Our Case Number: ACP-323060-25

Re: Mayo County Council Ballina Flood Relief Scheme Compulsory Purchase Order No 1 of 2025
River Moy, County Mayo

Ballina Flood Relief Scheme
Case reference: CH16.323060

Address: Hunts, Behybaun, Ballina, County Mayo, F26 FW32

**T71 AS SHOWN ON: - MGW0290-RPS-00-XX-DR-D-WL007-02**

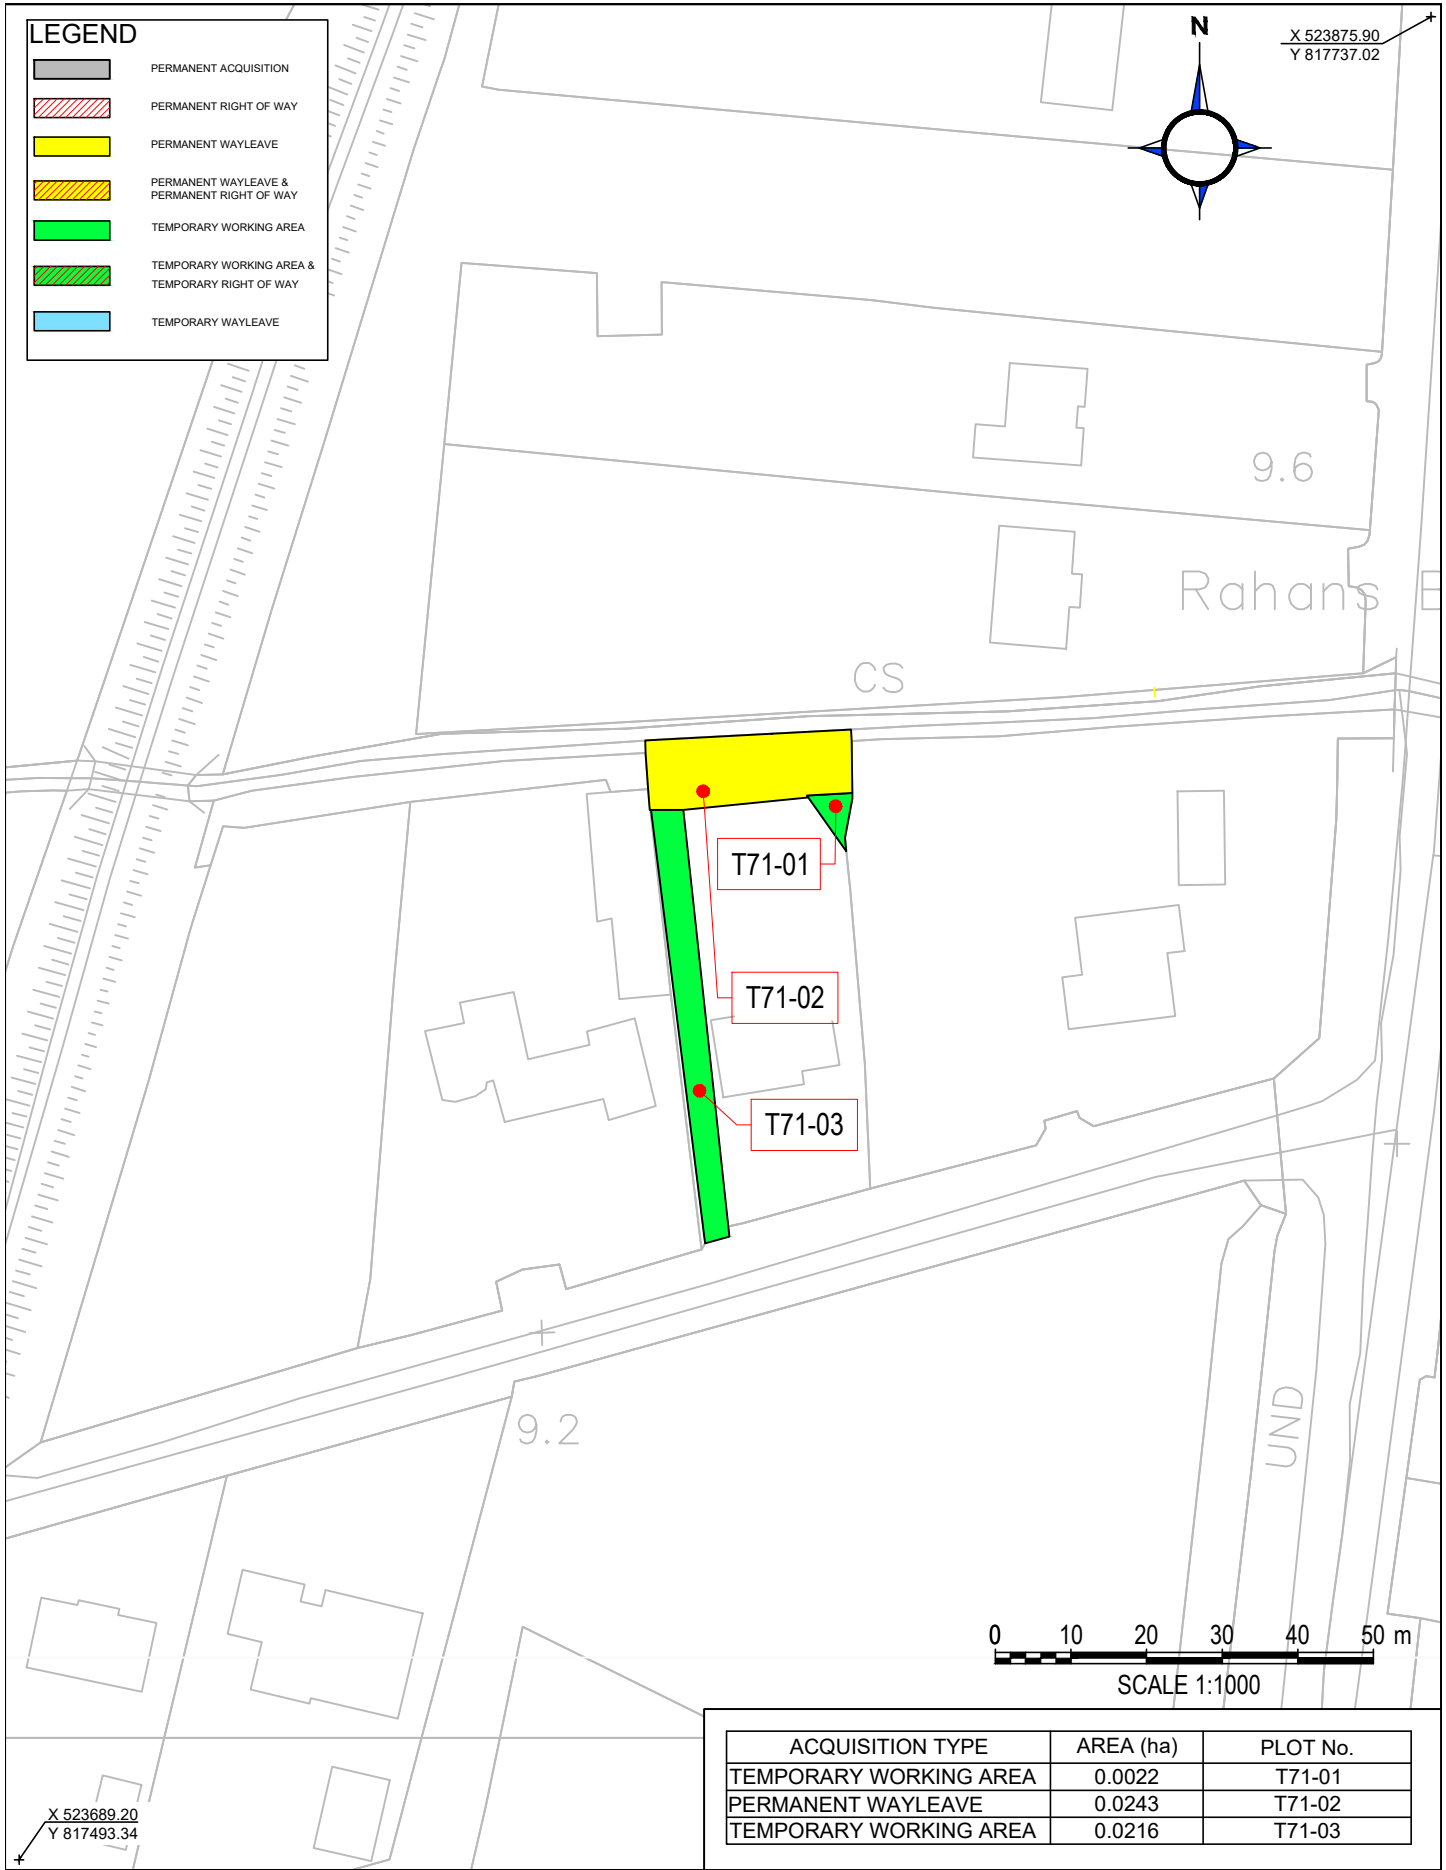
The Local Authority is seeking permanent wayleaves (refs. T71-02) and temporary working areas (refs. T71-01 & T71-03) amounting to a total of 481sq.m of our residential property. This would have inexplicable impact on the enjoyment of this property for our family, removing gardens, hindering privacy and generally destroying the suburban residential character of the area.

Proposals that had been submitted with the flood risk assessment do not clearly set out the intention for the entire area of my property subject of the CPO notice. In short, we are unclear as to how our property would be treated, including landscaping, boundaries and services, and why our property is to be acquired.

While we recognise the wider societal benefits in undertaking the associated flood risk scheme, the extent of ground required from our property is grossly excessive, particularly when considering the following:

- more convenient maintenance access to the river channel along the north of my property would be available from the properties to the north that are either vacant or undeveloped. These unoccupied properties, including their extensive rear hardstandings, also provide greater scope to be incorporated

into the flood relief measures, with substantively less impacts on property owners;

- the extent of area required is excessive and exorbitant relative to the identified flood design levels, including freeboard, the existing flood prevention measures and the associated works intended as part of the flood relief scheme in this area, including a flood wall measuring 0.86m in depth along the northern boundary of my property – subsurface works are noted but these do not necessitate the permanent loss of property;
